Application for Planning Permission for Works or Extension to a Dwelling

Development: Proposed single storey side extension.
Location: 44 Sea Lane Pagham PO21 4UJ

Proposed Elevations

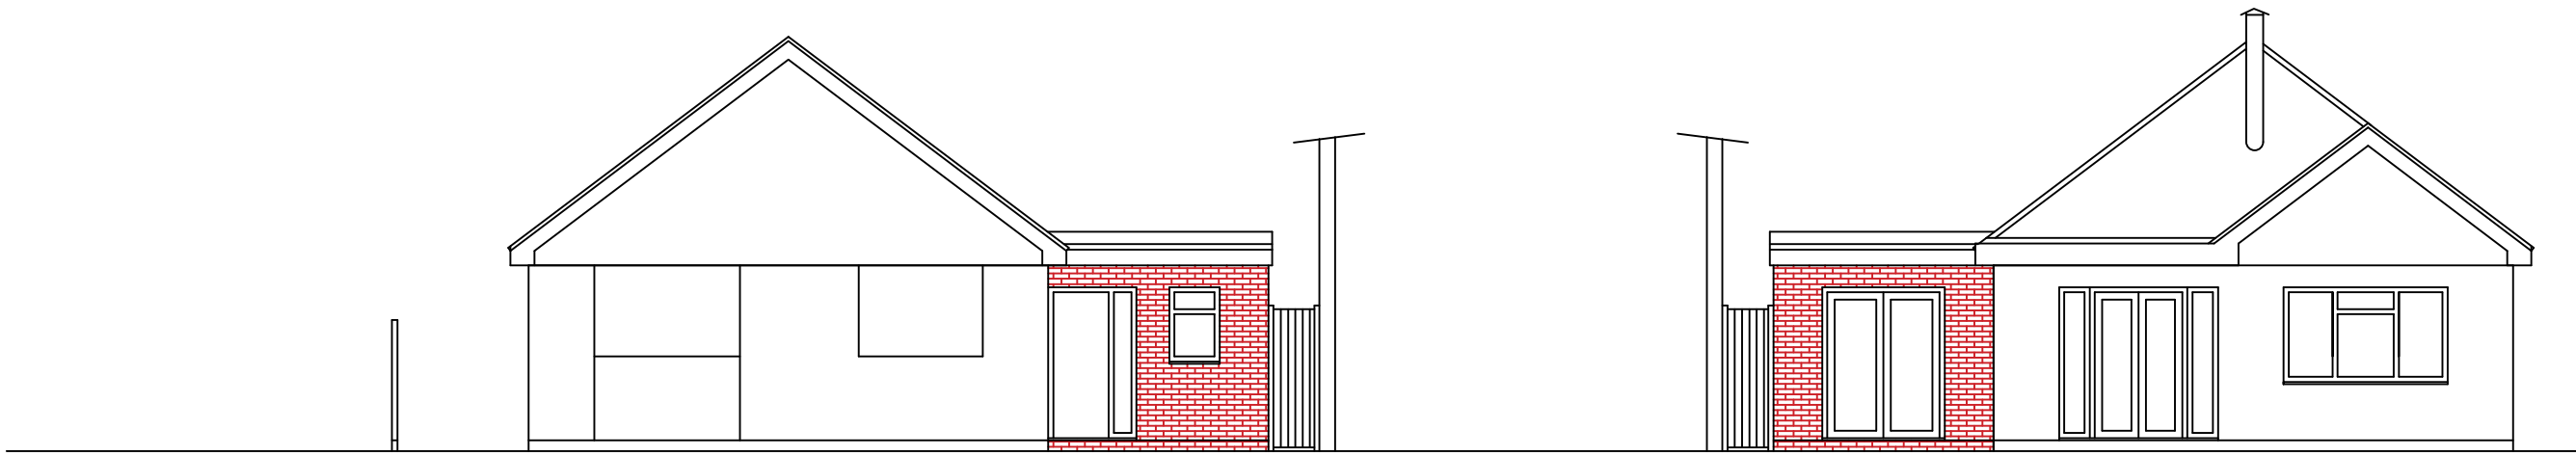
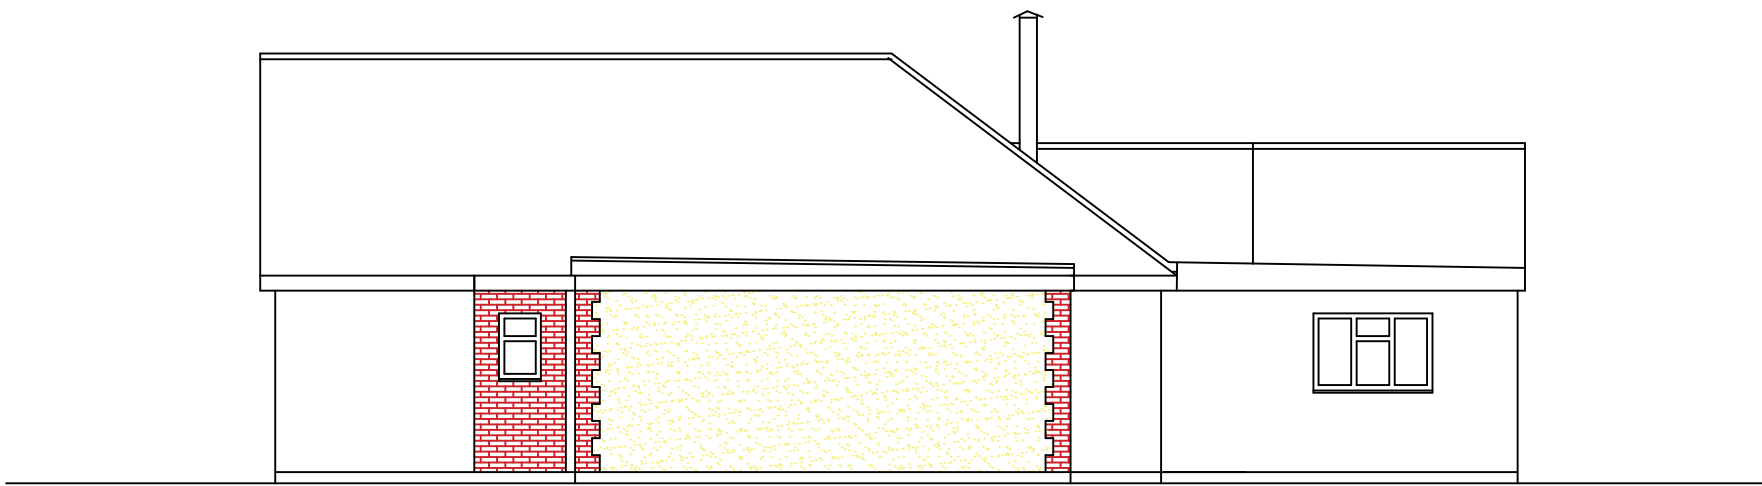
Elevations

Please add north, south, east, west labels to your elevation plans.

Block plan 1 : 500

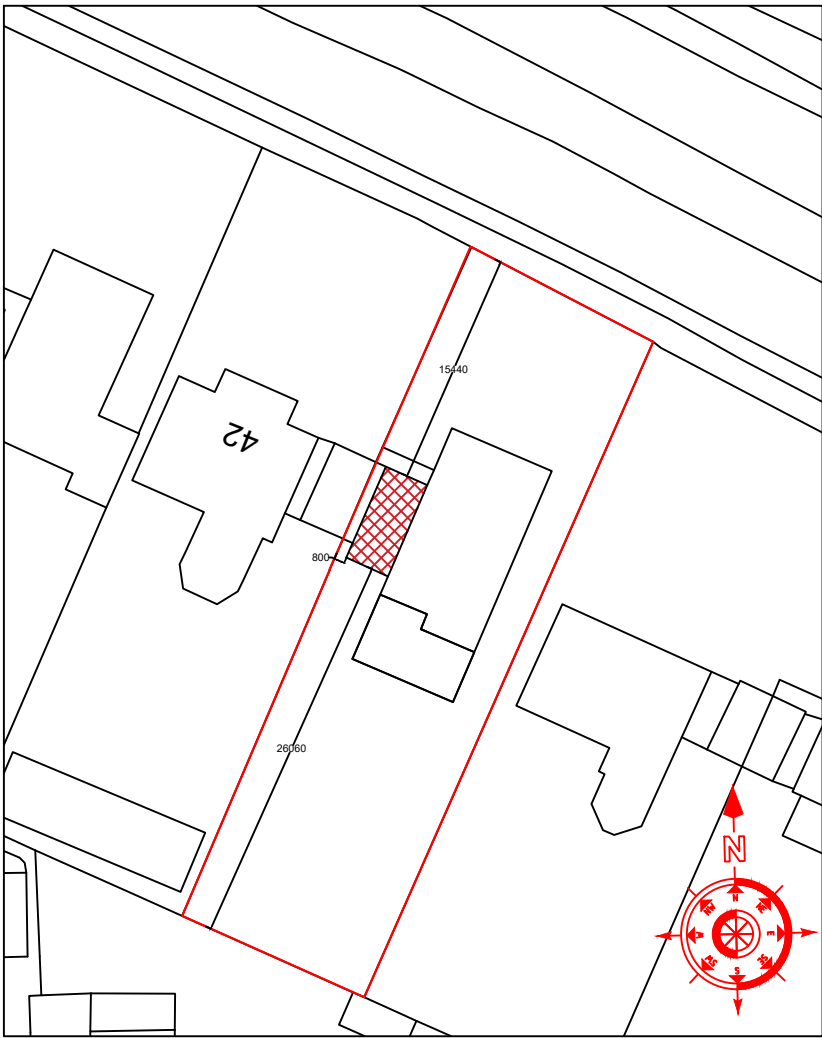
Block Plan

Please add a north point to your block plan and we also require distances to boundaries. Further details of what must be included on the plan can be found in the Validation Requirements List.
